Planning Application Ref: AL/51/19/PL

Location: Springfield and land to rear, Hook Lane, Aldingbourne, PO20 3TE

Description of works: Demolition of the existing dwelling & erection of 3no. 2-bed, 3no. 3-bed & 4no. 4-bed dwellings, access, landscaping & associated works

Fig 7 - Proposed Site Layout Plan

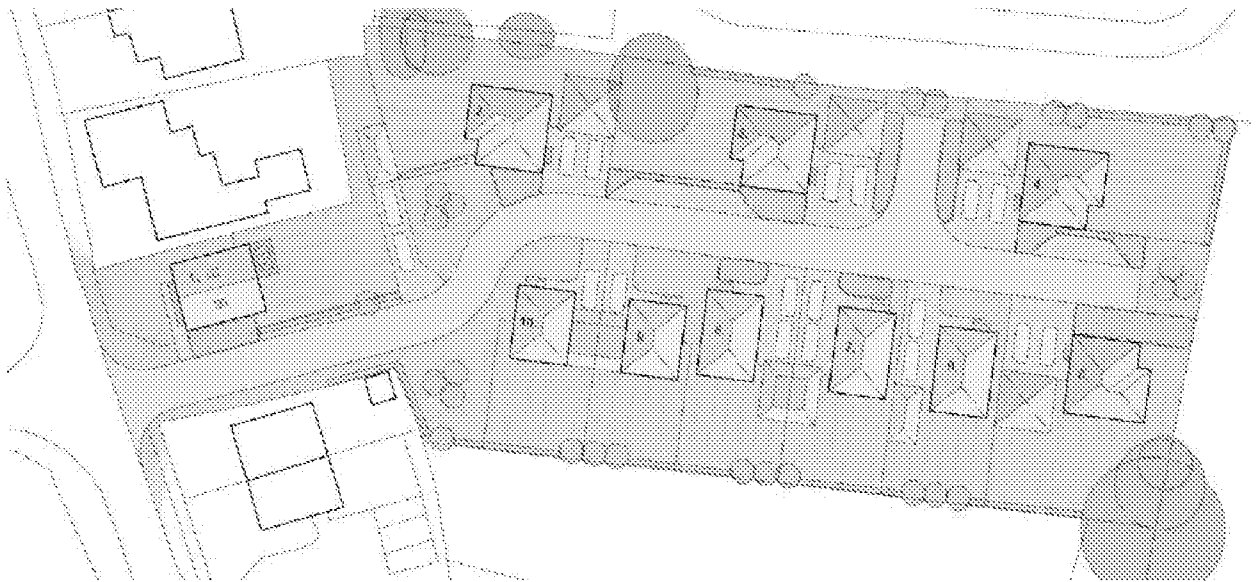
- The number and position of dwellings proposed for this parcel of land is such that very few trees of current and/or long-term value would be retained.

- As it stands, I feel unable to lend my support to this scheme and so must register an **OBJECTION**. A reduction in the number of units from 10 to 7 (removing plot 2, 3 & 4) would allow for the long-term retention of important boundary trees, which I could support.
- I recommend the making of a Tree Preservation Order in respect of one pedunculate oak (T23 on the applicant's survey) to preserve its place in the landscape. I attach TEMPO form and GIS plan for this purpose.
